From: Martyn White <Martyn.White@arun.gov.uk>
Sent: 20 December 2019 15:56
To: Planning.Responses <Planning.Responses@arun.gov.uk>
Subject: AW/313/19/HH

AW/313/19/HH

The proposal is for a single storey rear extension as well as two dormers (one to the front and one to the rear of the building).

Drawing Title:
PROPOSED FLOOR PLANS & ELEVATIONS

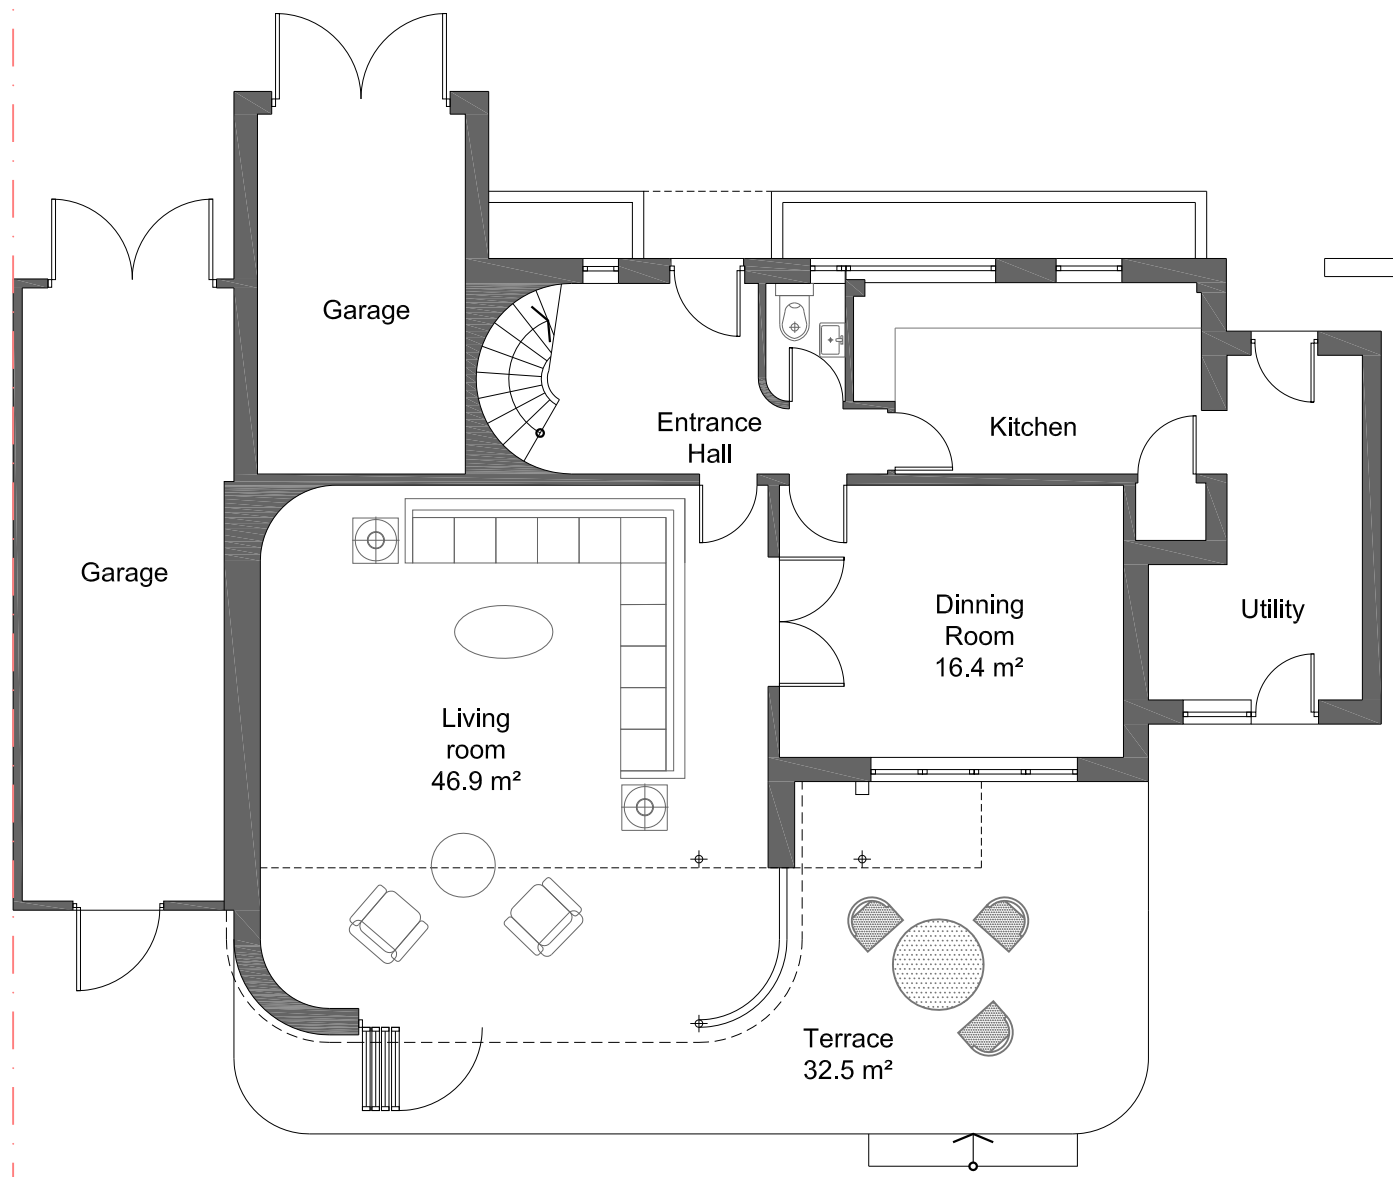
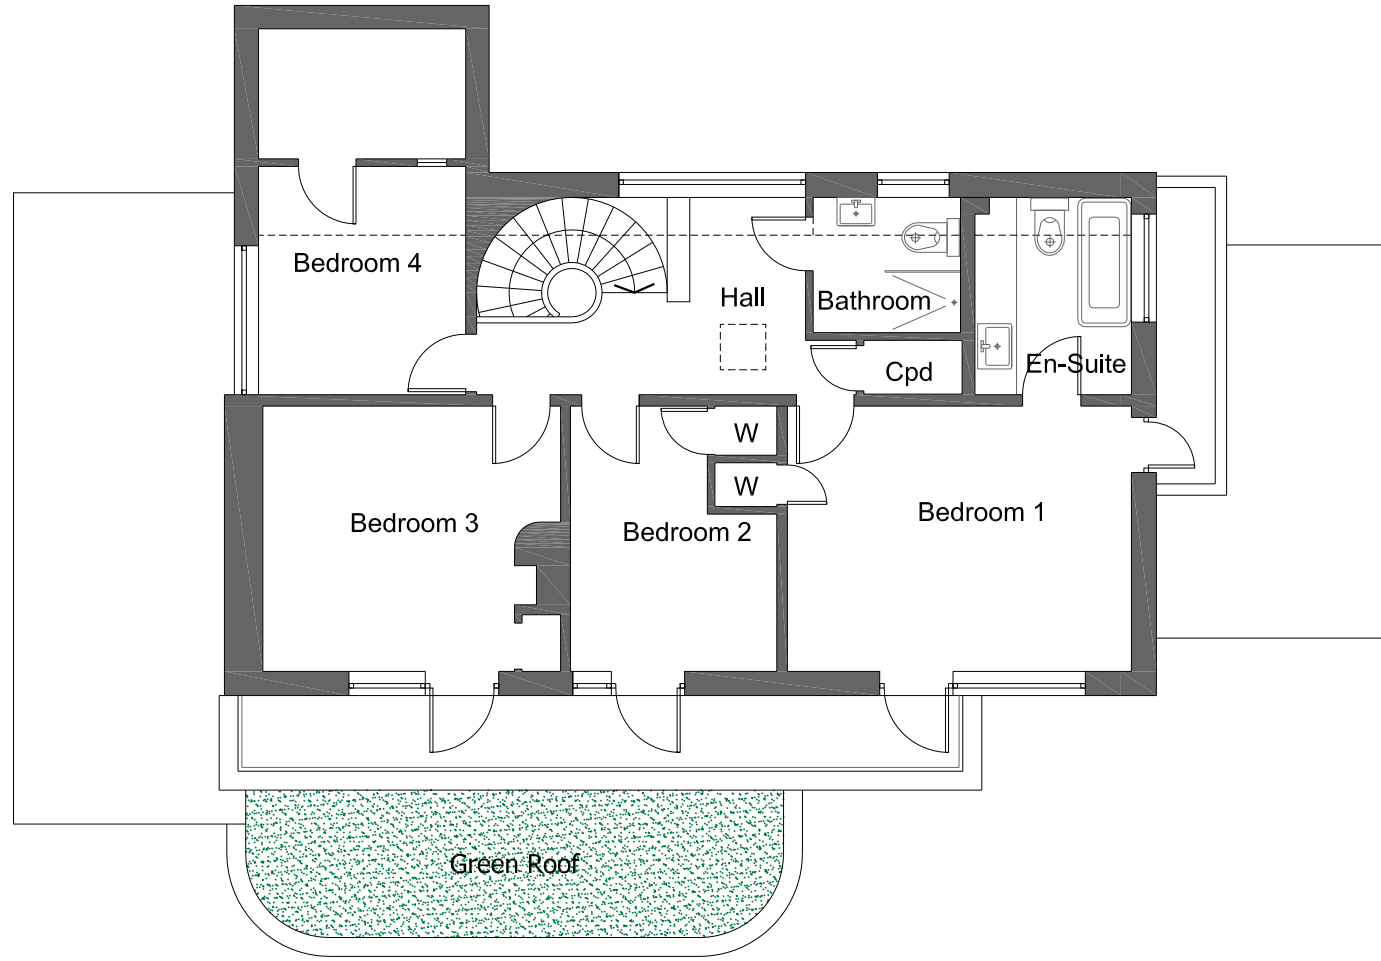
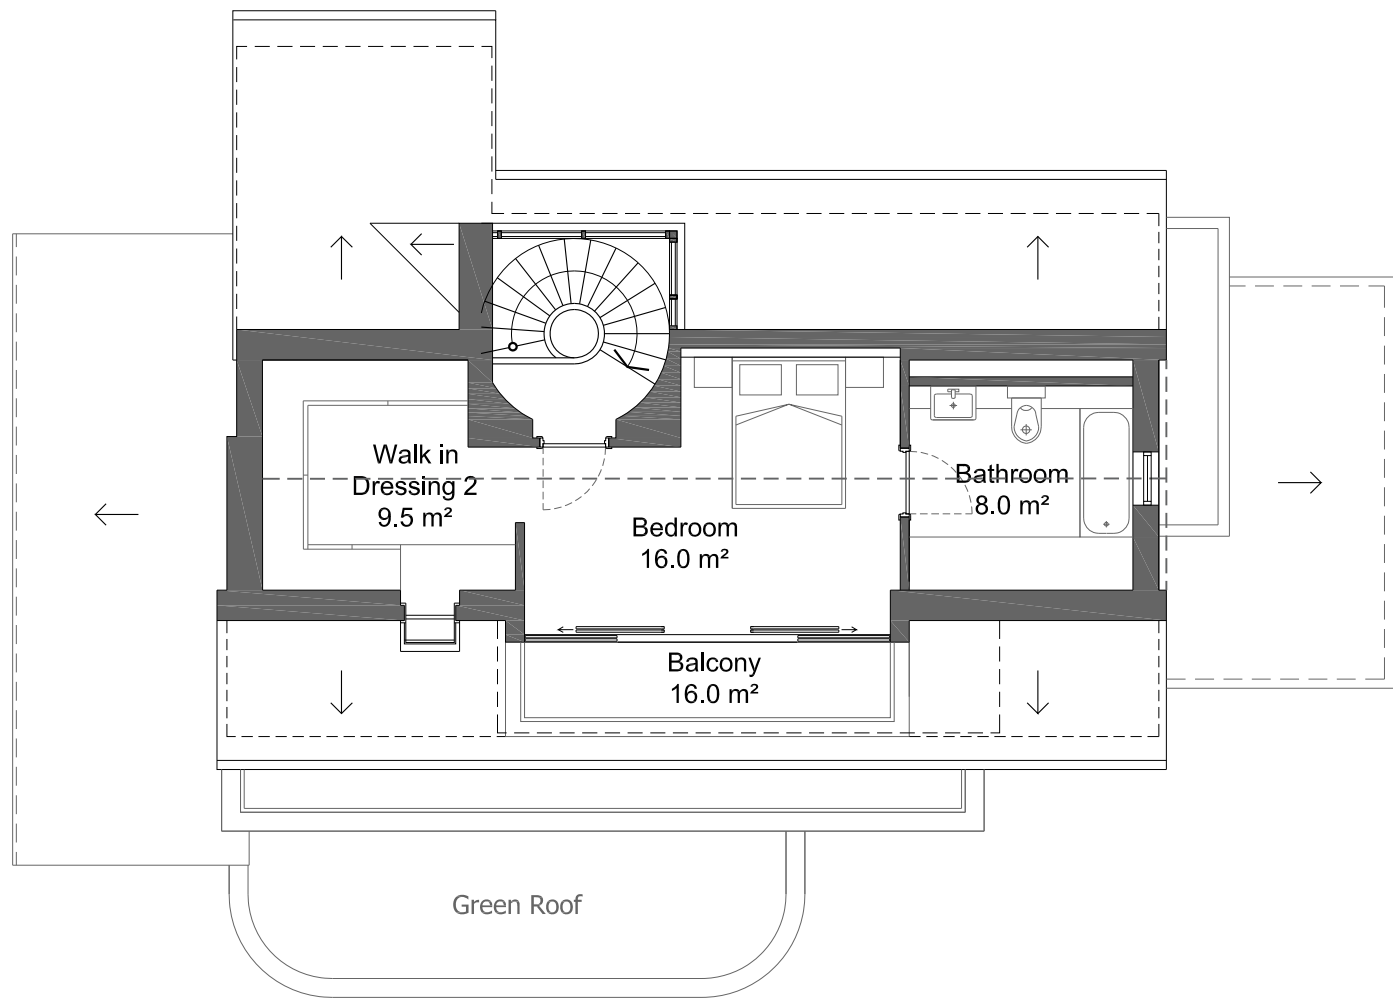
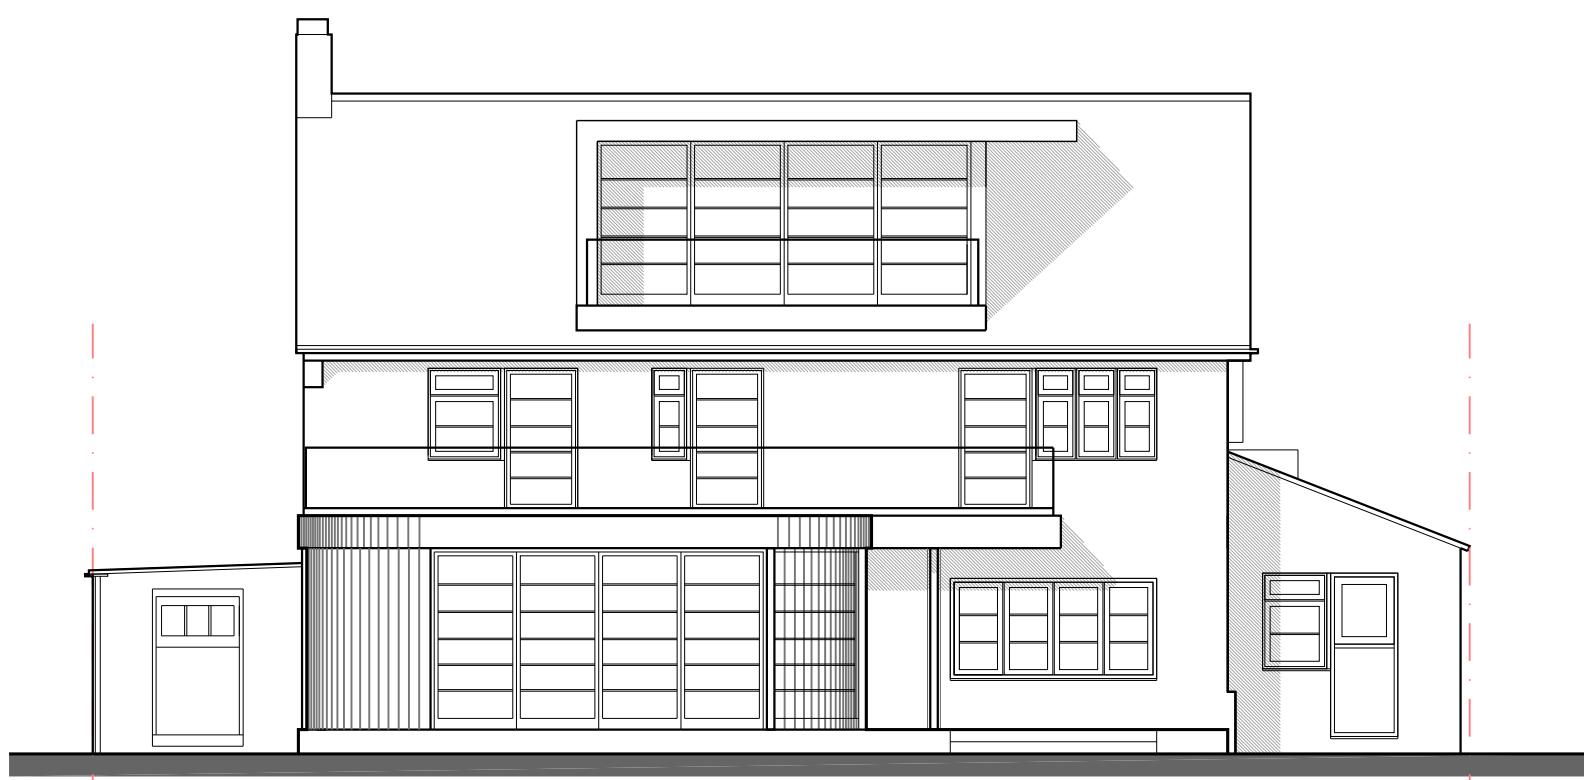
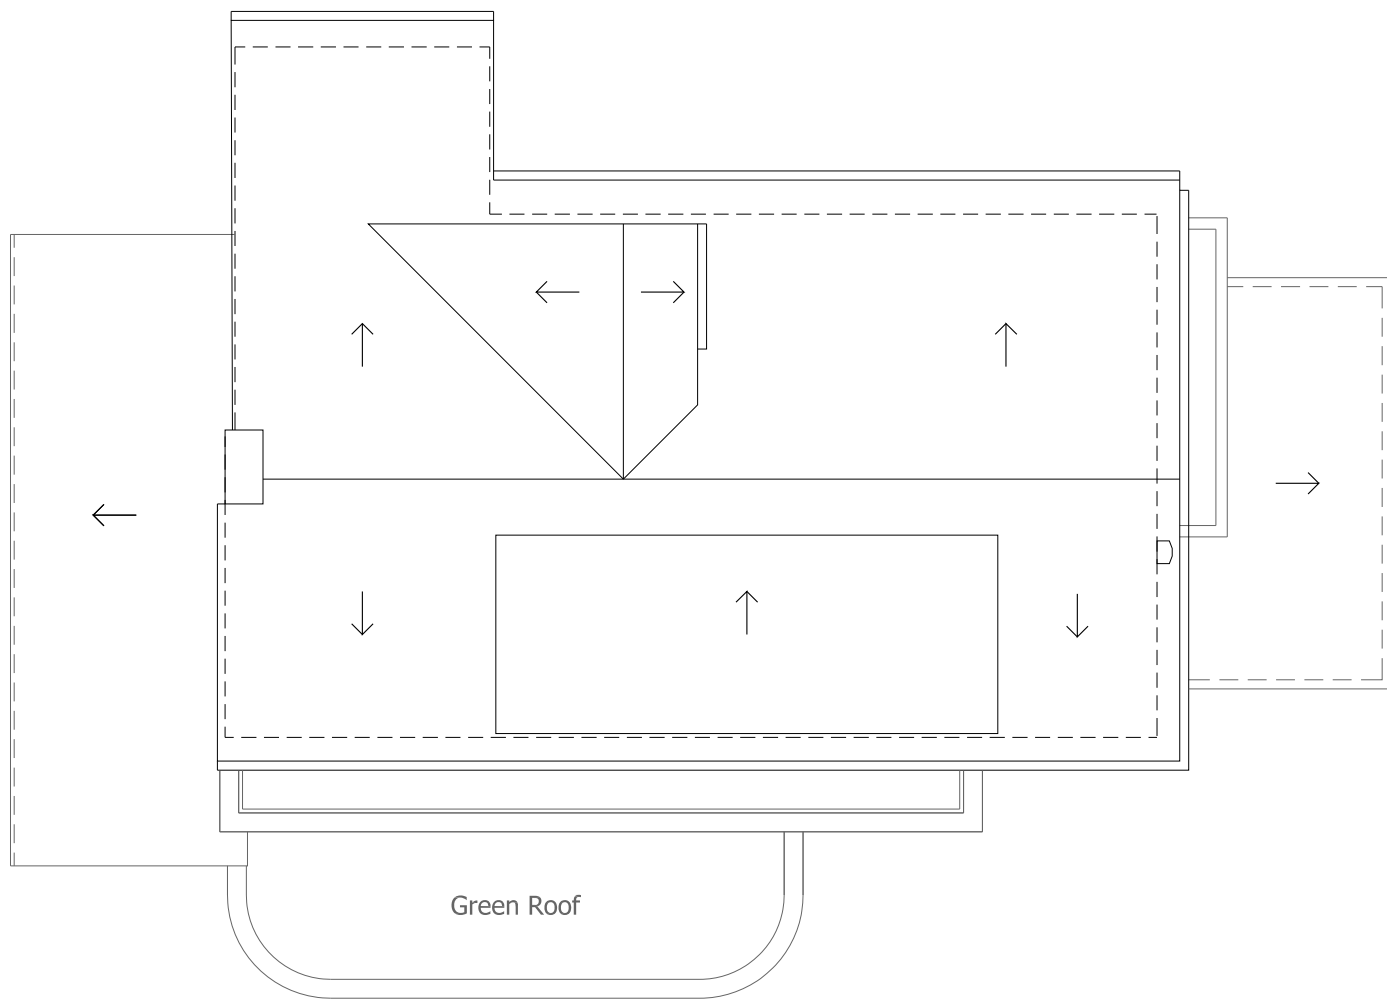
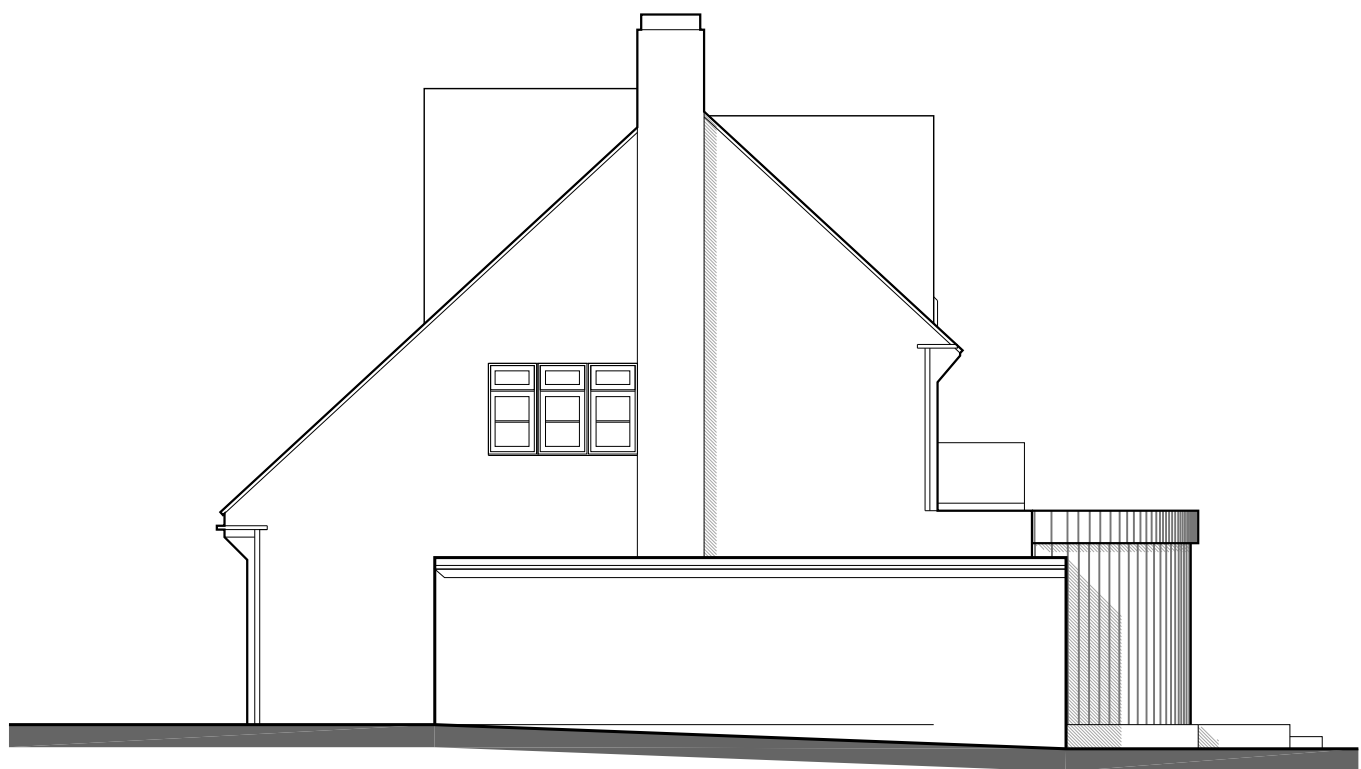
The single storey rear extension appears to be sensitively considered taking into account the age and appearance of the host dwelling. I particularly like the use of the curved walls. Likewise, the proposed balcony appears to be discrete and will have a neutral impact upon the building.

The proposed dormers are more of interest, whilst they are reflective of a considered design approach, they are problematic with respect to their size. Of the two dormers, the front one is especially of concern due to its size; it is a large structure, which dominates the elevation. It would also conflict with the horizontal emphasis provided for by way of the existing window treatment on the ground and first floors. Whilst it is acknowledged that it has been shaped so as to reduce its size, and therefore dominance on the elevation, it is felt that it is still negative.

It is suggested that, if minded to approve the application, that a condition regarding the joinery be used so as to ensure that the windows/doors are sufficient quality to reflect both the host dwelling and the quality of the new design.
